MEMORANDUM

SUBJECT: SF-23-006 – Saddlehorn Ranch Filing No. 4
First Submittal

Engineering Division

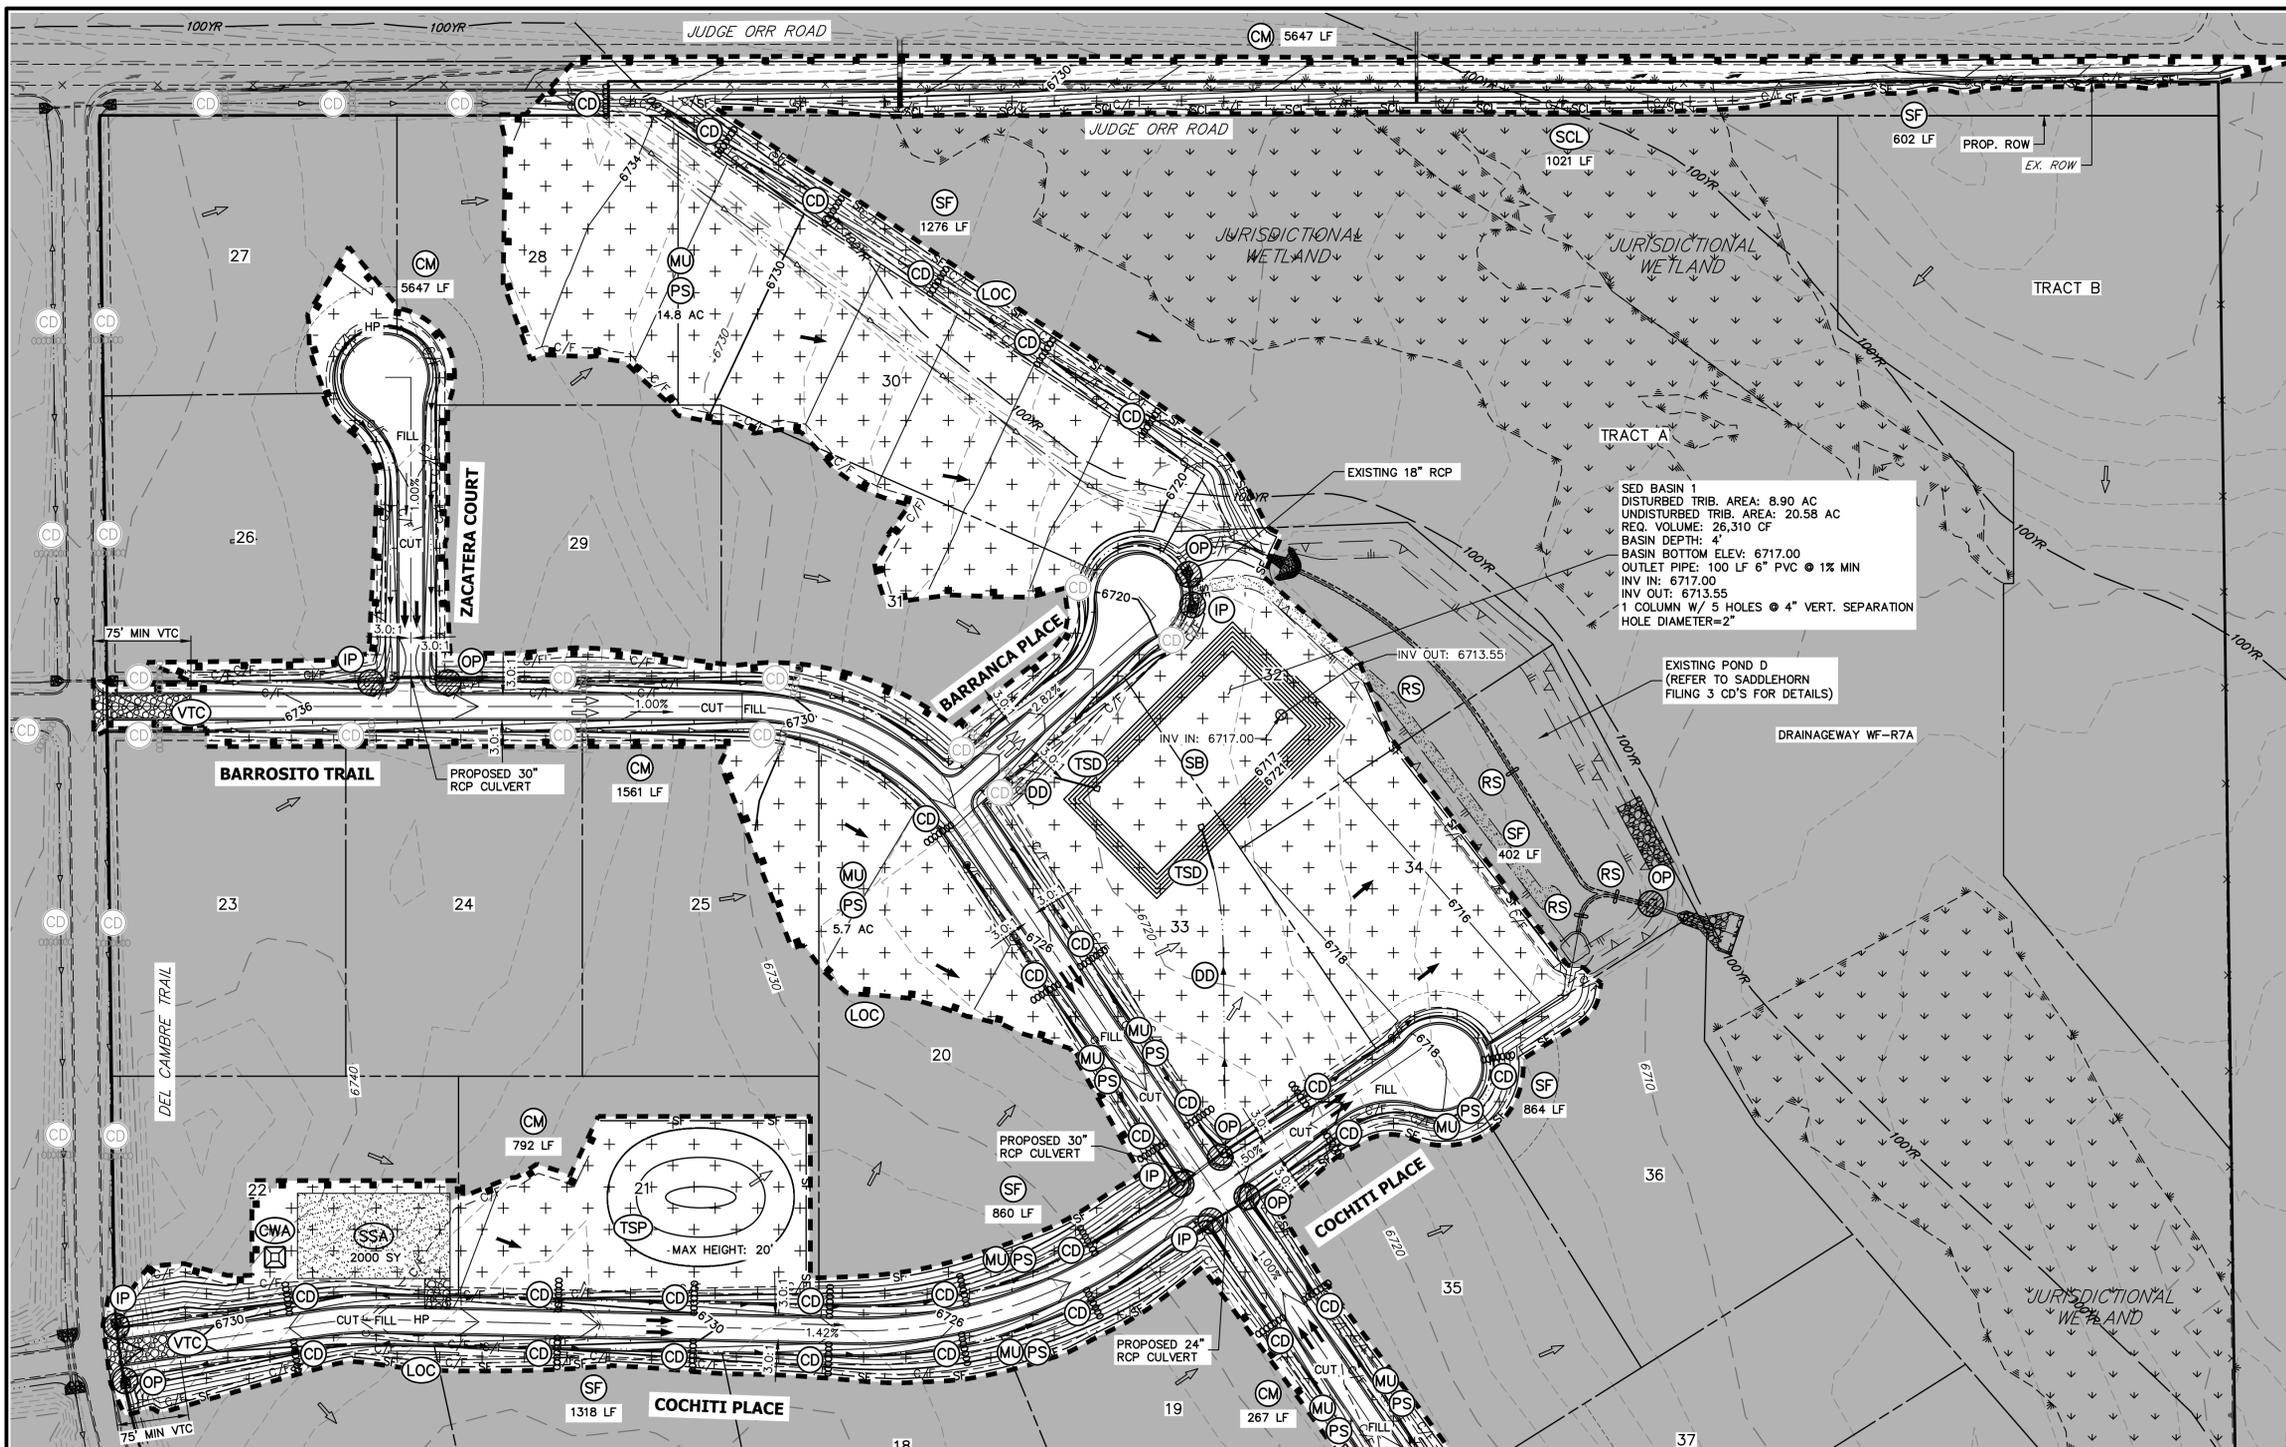
1. See CD/GEC Plan redlines.
2. If channel stabilization is needed provide channel improvements CDs. Supercritical flows are of concern.
3. If there will be USPS mail kiosk/cluster in this subdivision provide locations on the CDs.
4. Note for Filing 3: Barrosito and Del Cambre street name signs at Judge Orr must meet size requirements for the posted speed on Judge Orr Road.
5. Ensure that all requirements of ECM Appendix C are met in the Soils and Geotechnical report, specifically regarding groundwater. Note that any exposed groundwater will be the responsibility of the developer or district to address, including any requirements of the Upper Black Squirrel Creek Groundwater Management District.

# SADDLEHORN RANCH FILING NO.4

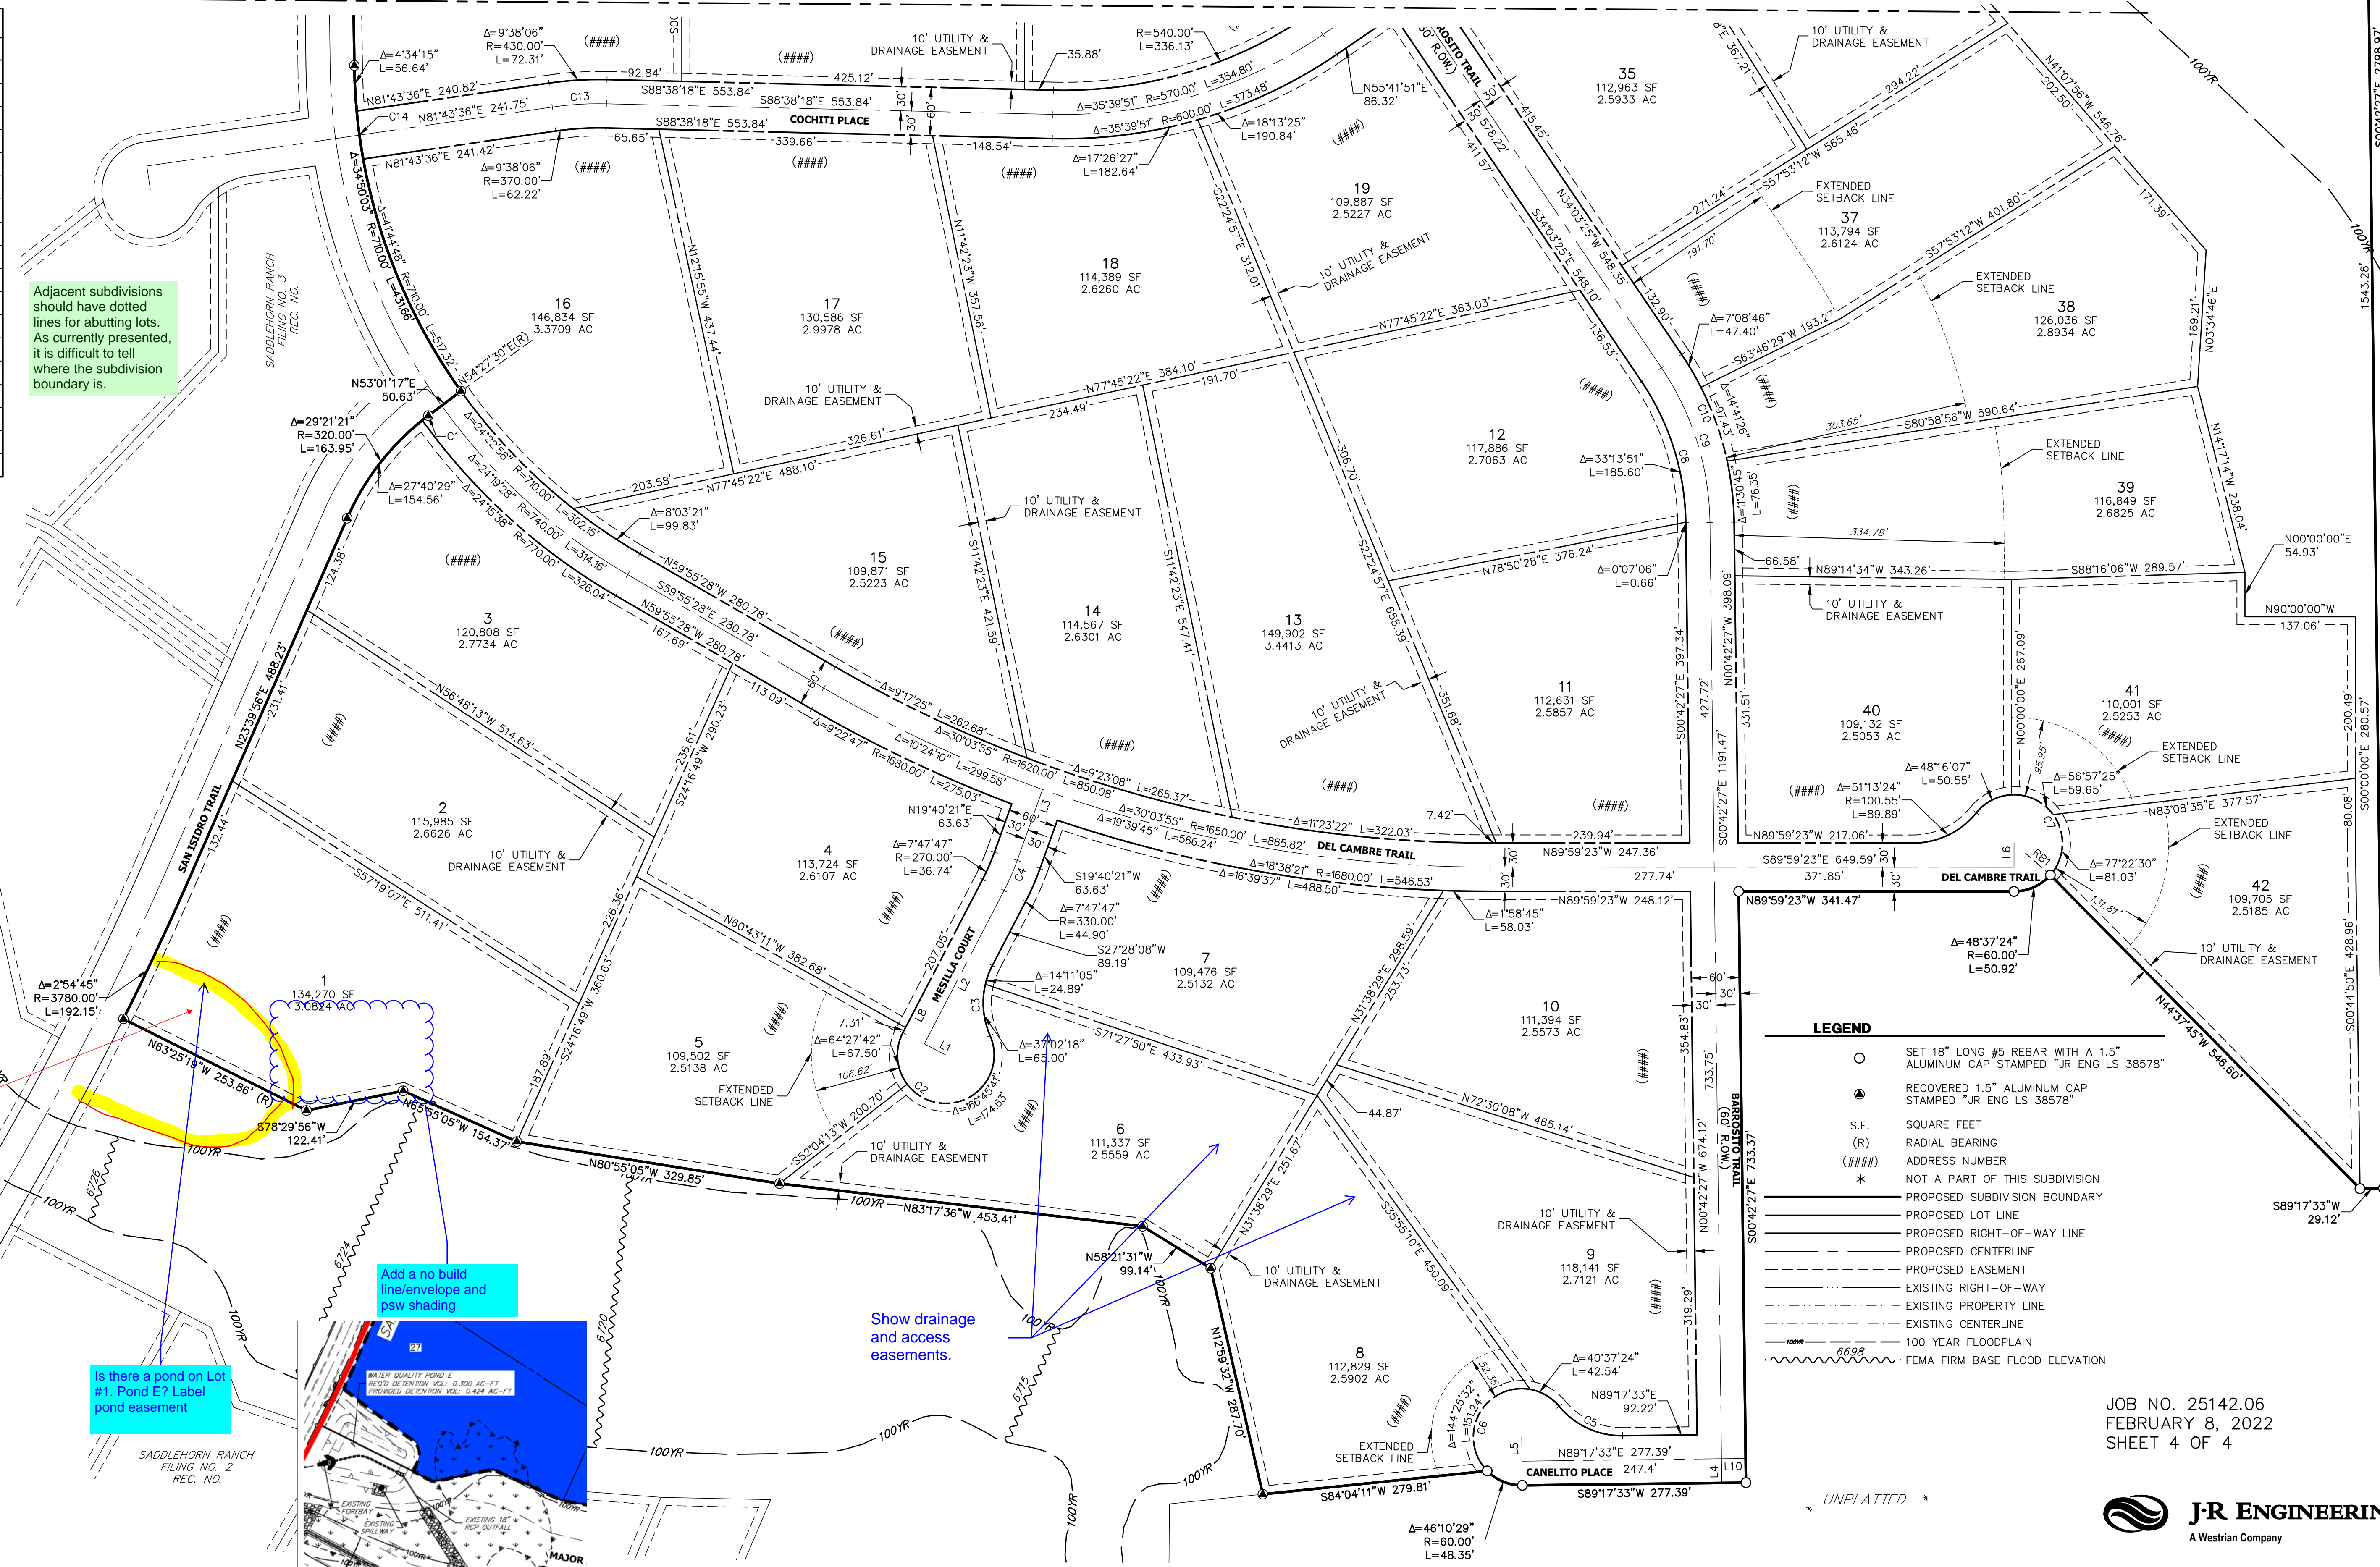
1. See LOI redlines.
2. See Final Plat redlines.
3. Note: FEMA-approved base flood elevations (BFEs) need to be shown on the plat.
